**Date:** 11/29/2021

**Re:** **HVAC Platform**  
Location: Lot 223 Wood Grove (Fuquay-Varina, NC)  
JDS Project No.: RDU2112454  
Date of Inspection: 11/30/21

Job 21-5978-R01	Truss R07	Truss Type Common	Qty 2	Ply 1	49786-0223 WOODGROVE   FUQUAY VARINA, NC	# 28820
--------------------	--------------	----------------------	----------	----------	------------------------------------------	---------

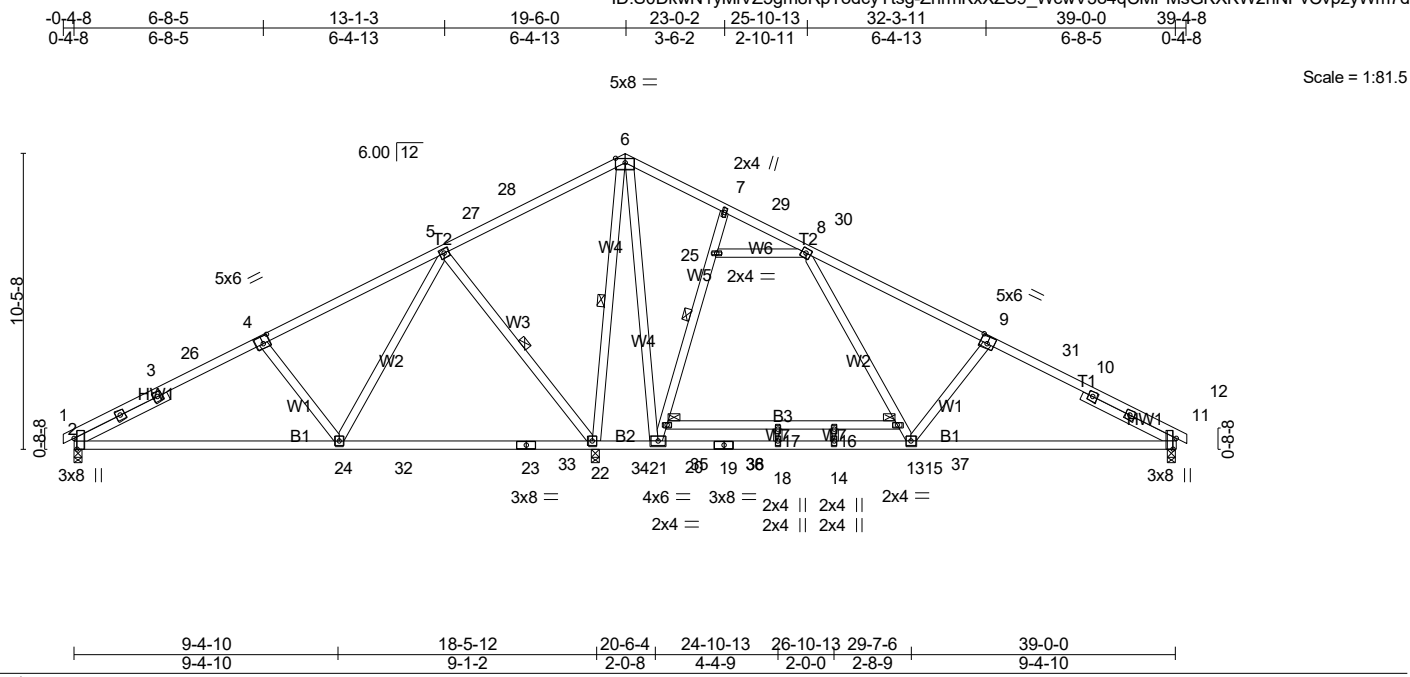
The HVAC platform has been installed to the right of center at trusses R07, R08, and R09. A new platform is needed to the left of center between joints 22-24 at truss R07, 23-25 at truss R08 and 22-24 at truss R09.

- Install vertical 2x4 blocks installed 16" o.c. on both faces of the truss. Fasten to the bottom chord with minimum (4) equally spaced 10d nails. **(Green)**

- Install a vertical 2x4 block in the plane of the truss between the scabs referenced above, cut to fit tightly between the bottom chord of the truss and the bottom of the new horizontal 2x4 forming the HVAC platform. **(Yellow)**

- Install horizontal 2x4 members to support the sheathing of the HVAC platform. Fasten the 2x4 members to the vertical 2x4 blocks on each face of the truss with (4) equally spaced 10d nails. The horizontal member should extend flush to the adjacent webs, mitering the ends as needed to provide full bearing. Fasten the end to the adjacent webs with (2) 10d toe nails at each end. **(Blue)**

- Install ¾" floor sheathing and fasten to the horizontal members cited above. Fasten with (1) 8d nail spaced 6" o.c. into all sheathing edges and (1) 8d nail spaced 12" o.c. in the field.
